facsimile transmittal

To: Diversified Properties **From:** Mike Nugent/Jeanie Bourke
Fax: 773-6875 **Date:** December 2, 2002
Phone: 773-4988 **Pages:** 1
Re: 33, 36 & 40 Barclay Ave.

(339 D007, 339 E018 & 339 E016)

I have completed the review and have the following questions/comments?

**FIRST FLOOR PLAN**  
SCALE: 1/4" = 1' - 0"

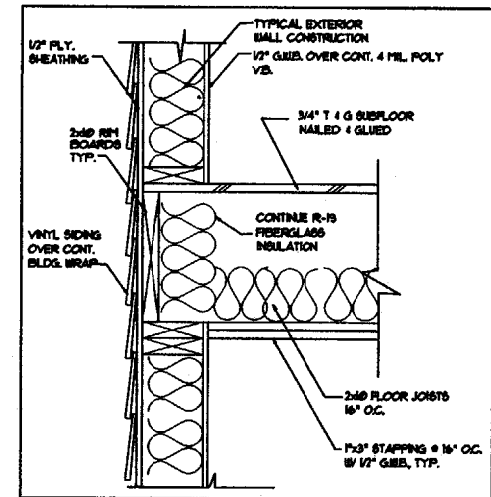
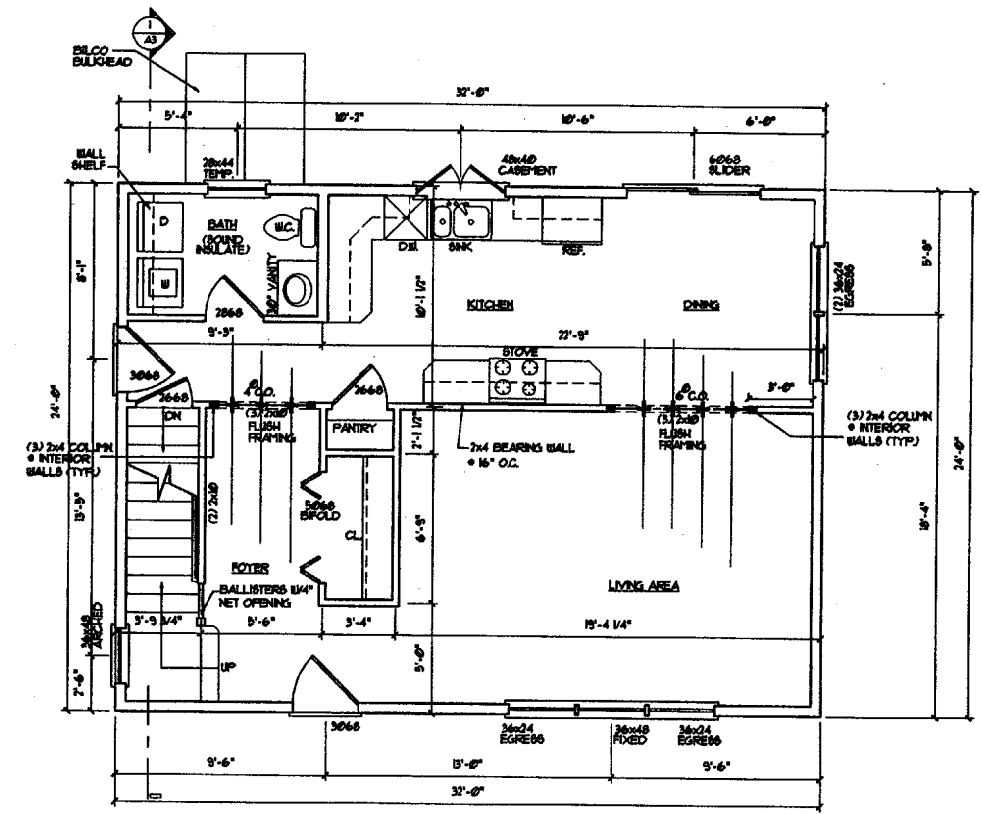
- 13) On page A2/ First floor plan the 2- 2" x 10" centerbeam is underdesigned for an 8 foot opening.
- 14) What is the header for exterior windows & slider.

FOUNDATION / FIRST FLOOR FRAMING PLAN

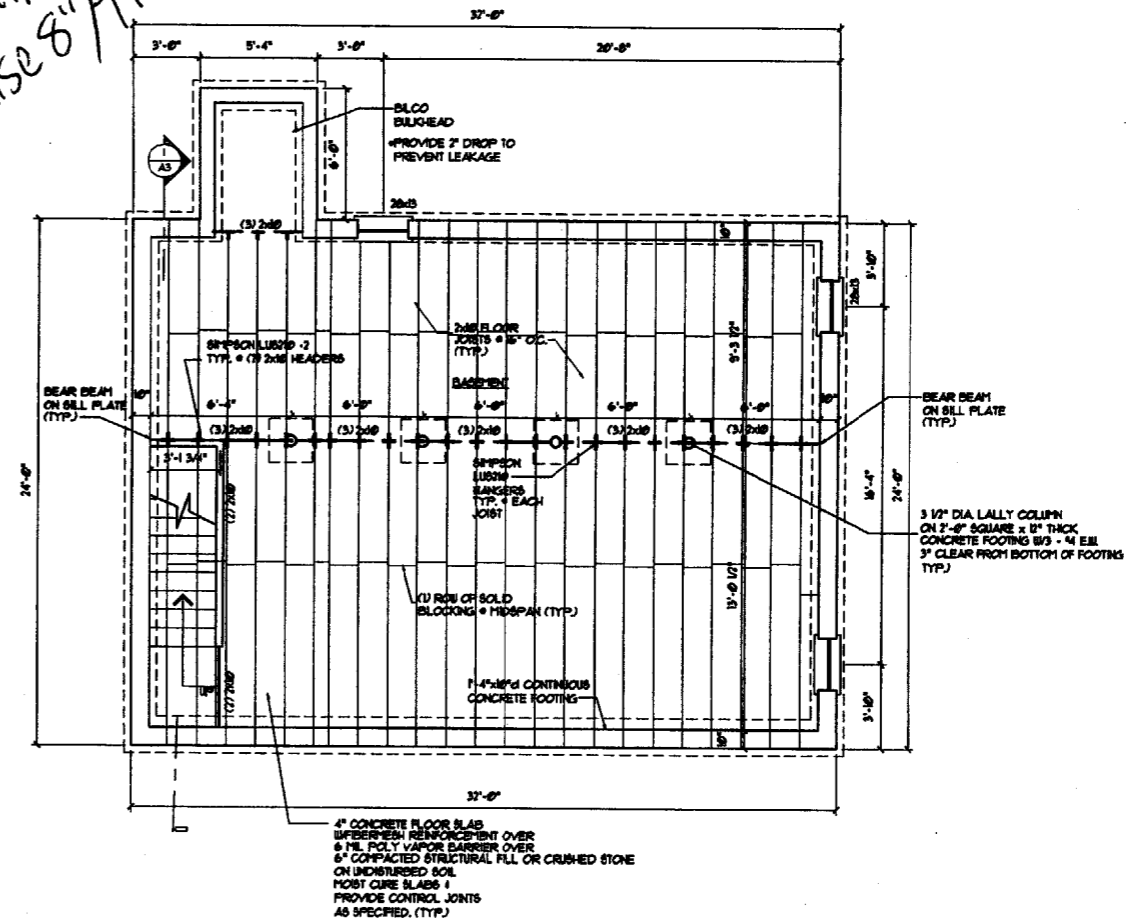
- 1) What is the type/size of the anchor bolts?
- 2) The carrying girder is underdesigned the spacing of the lally columns is excessive
- 3) Wall Sheathing not shown
